26 May 2017

SWT16/00137/02
SF2016/235976
MM

**SSD 8025 - PROPOSED LIMONDALE SOLAR FARM, LOTS 4,11,12,13,15,21 & DP751179,
LOT 1,2 & PART DP1190069, 47 DP720256, LOT 44 DP751243, YANGA WAY, BALRANALD.**

Proposed intersection location
 Limondale Sun Farm
 Traffic impact assessment
 Figure 3.1

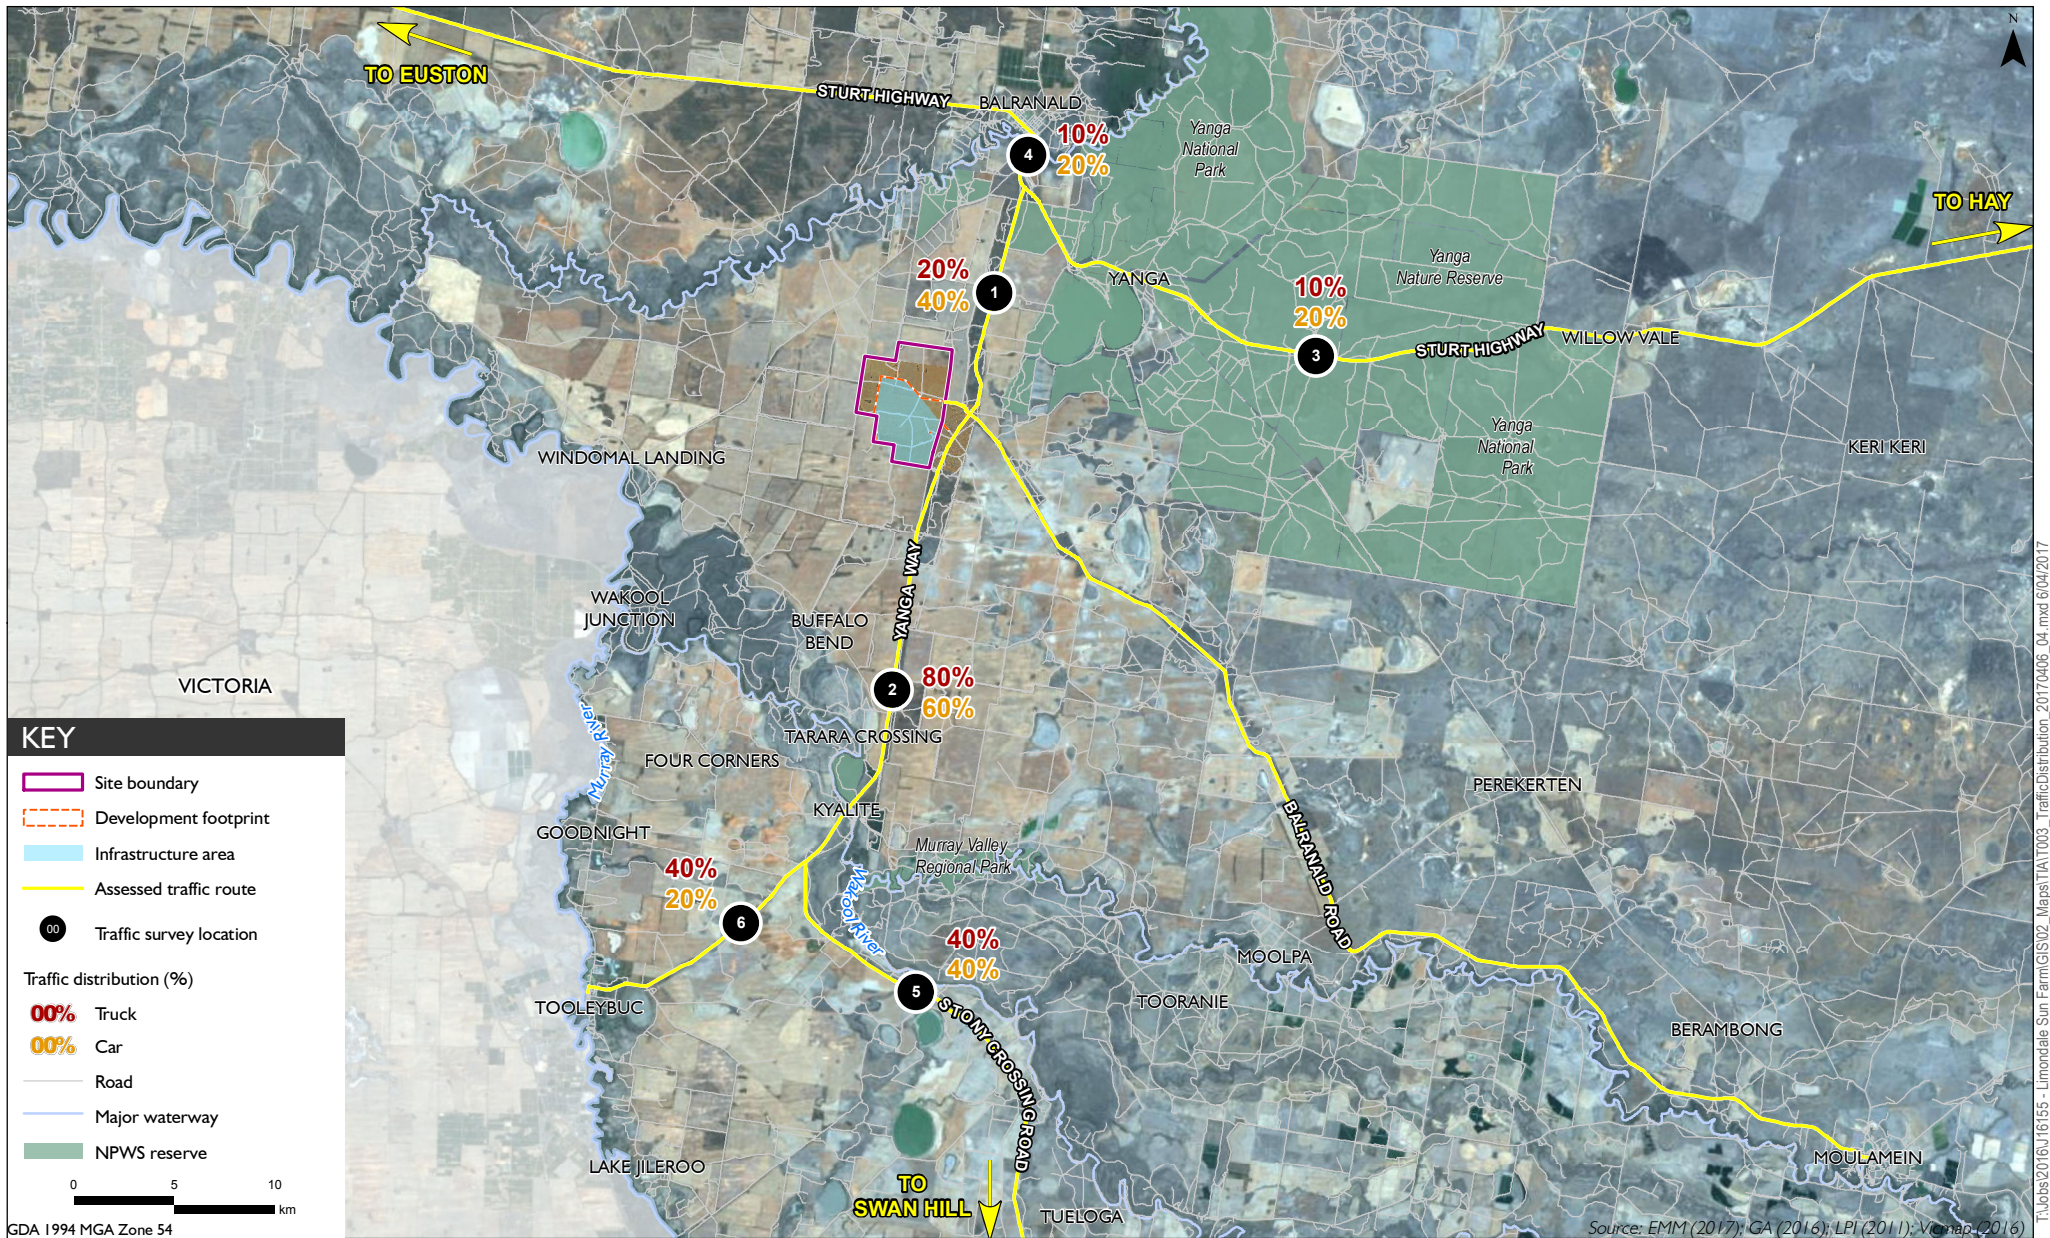
The submitted documentation indicates that access to the site is proposed from Yanga Way via a new intersection which is to be constructed approximately 150m south of the intersection of Balranald Road with Yanga Way. It is appropriate to require that all access to the development site be via the new intersection and not various other dirt tracks that access the site. Given the potential traffic generation, including light vehicles, being predominantly from the south the submitted reports propose the construction of a Basic Right Turn (BAR) and Basic Left Turn (BAL) intersection treatment at the intersection of the access road with Yanga Way.

4. As a minimum the intersection of the access road with Yanga Way is to be constructed and the roadside maintained so as to provide the required Safe Intersection Sight Distance (SISD) with a reaction time of 2.5 seconds in either direction in accordance with the Austroads Publications as amended by the supplements adopted by Roads and Maritime Services for the posted speed limit. Compliance with this requirement is to be certified by an appropriately qualified person prior to construction of the vehicular access.

5. As a minimum the intersection of the access road with Yanga Way is to be constructed with a Basic Right Turn (BAR) and Basic Left Turn (BAL) intersection treatment in accordance with the Austroads Guide to Road Design as amended by the supplements adopted by Roads and Maritime Services for the posted speed limit on Yanga Way. The intersection is to be constructed to the standards required for an approved road train route.

6. As a minimum the access road is to be constructed to provide for 2 way movement and be sealed for at least 50 metres from its intersection with Yanga Way. The intersection shall be designed and constructed so that vehicles turning between Yanga Way and the access road are not required to cross to the opposing travel lane in order to perform a turn manoeuvre. The intersection shall be line marked in accordance with Australian standards.

10. The intersection of the access roadway and Yanga Way is to be designed and constructed so as not to interfere with the capacity of the current roadside drainage network and to prevent water from proceeding onto, or ponding within, the carriageway of Yanga Way. If a culvert is to be installed and is to be located within the required clear zone of Yanga Way for the posted speed zone it is to be constructed with a traversable type headwall.
